Informal pre submission Consultation with Arun District Council

Angel Nursery Barnham on behalf of WSCC

Notes of meeting held on 26 Aug 2009

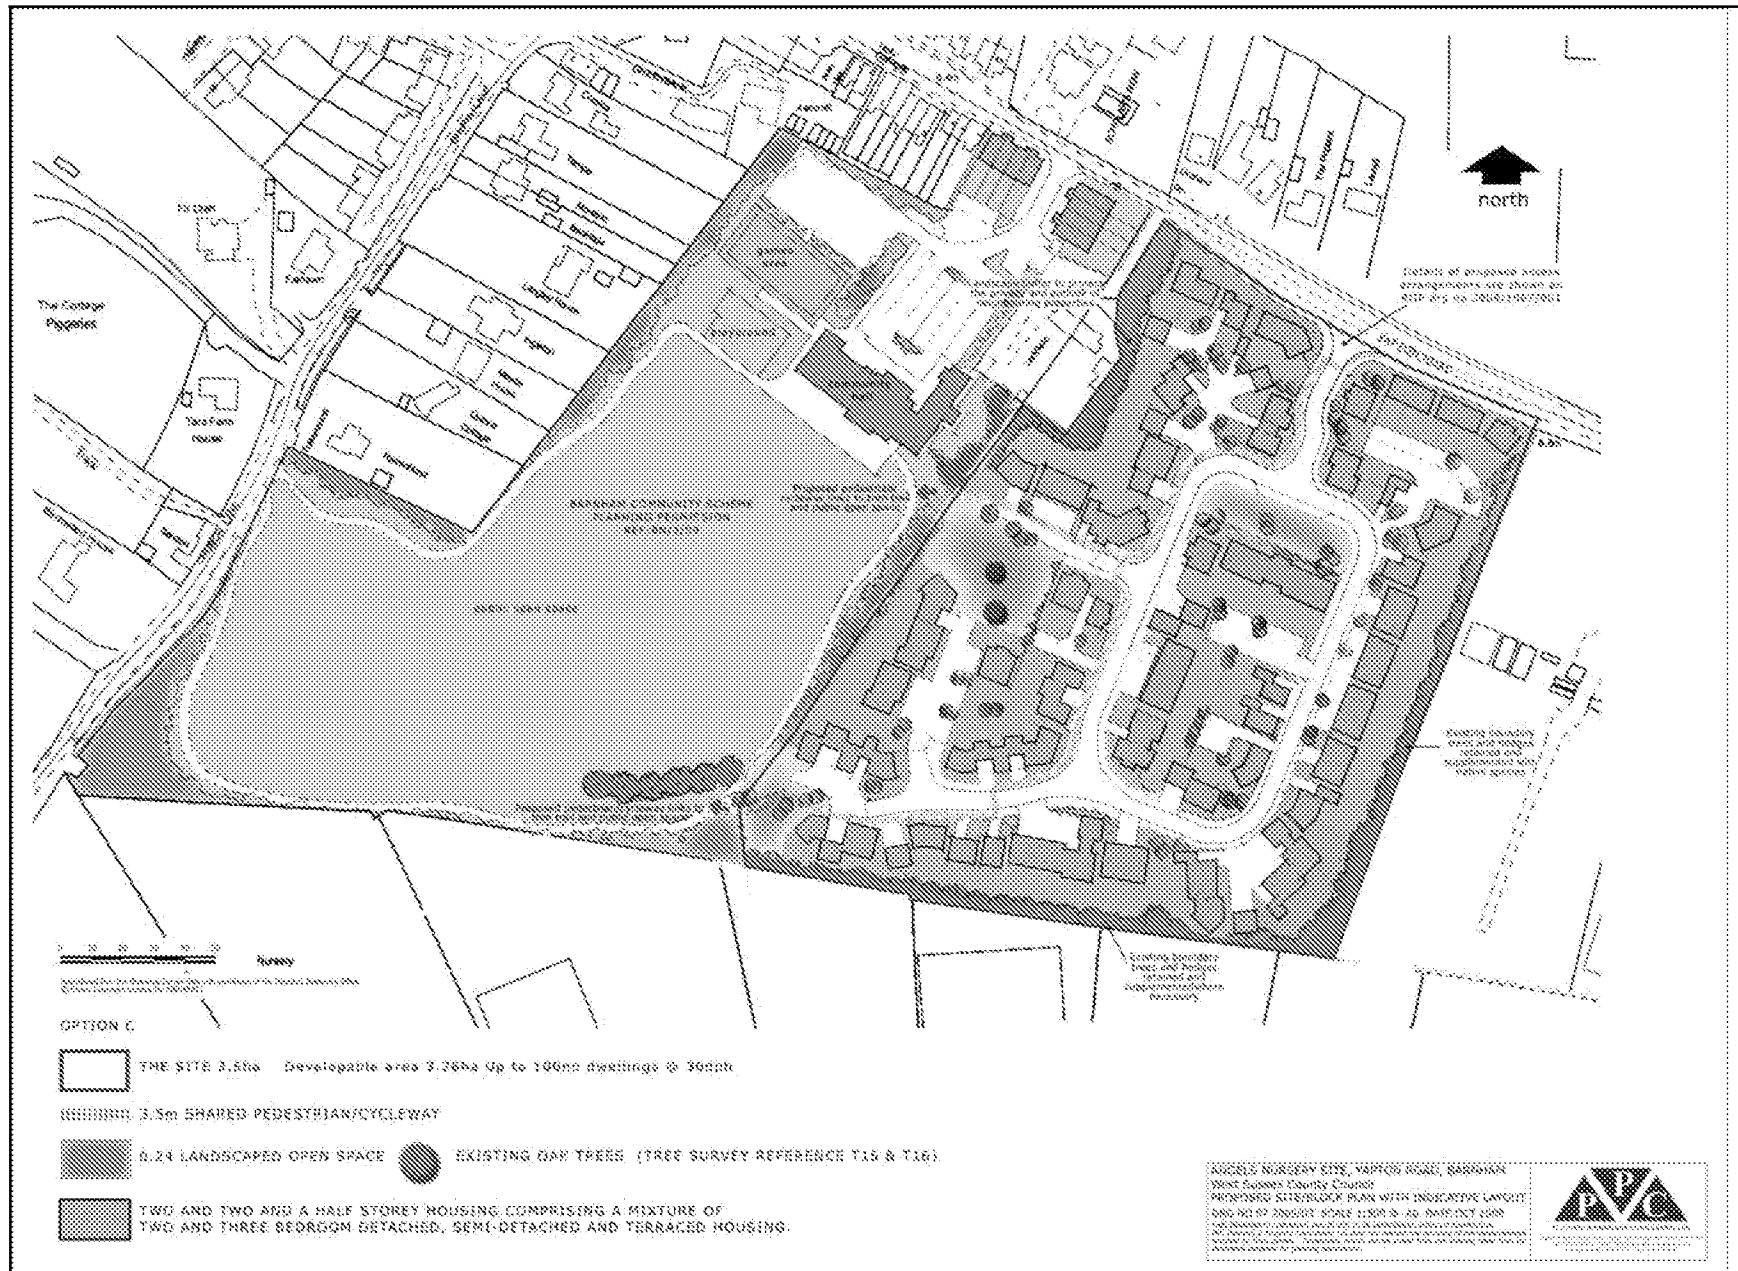
It was agreed that the Density & Housing Mix shown on the indicative layout appeared to be generally acceptable.

NC suggested that we reconsider the indicative scheme layout with particular regard to the location of play areas, landscaping/trees and the site frontage development onto Yapton Road to ensure that we could demonstrate compliance with relevant guidance regarding POS provision and protecting/reflecting the character of development in Yapton Road
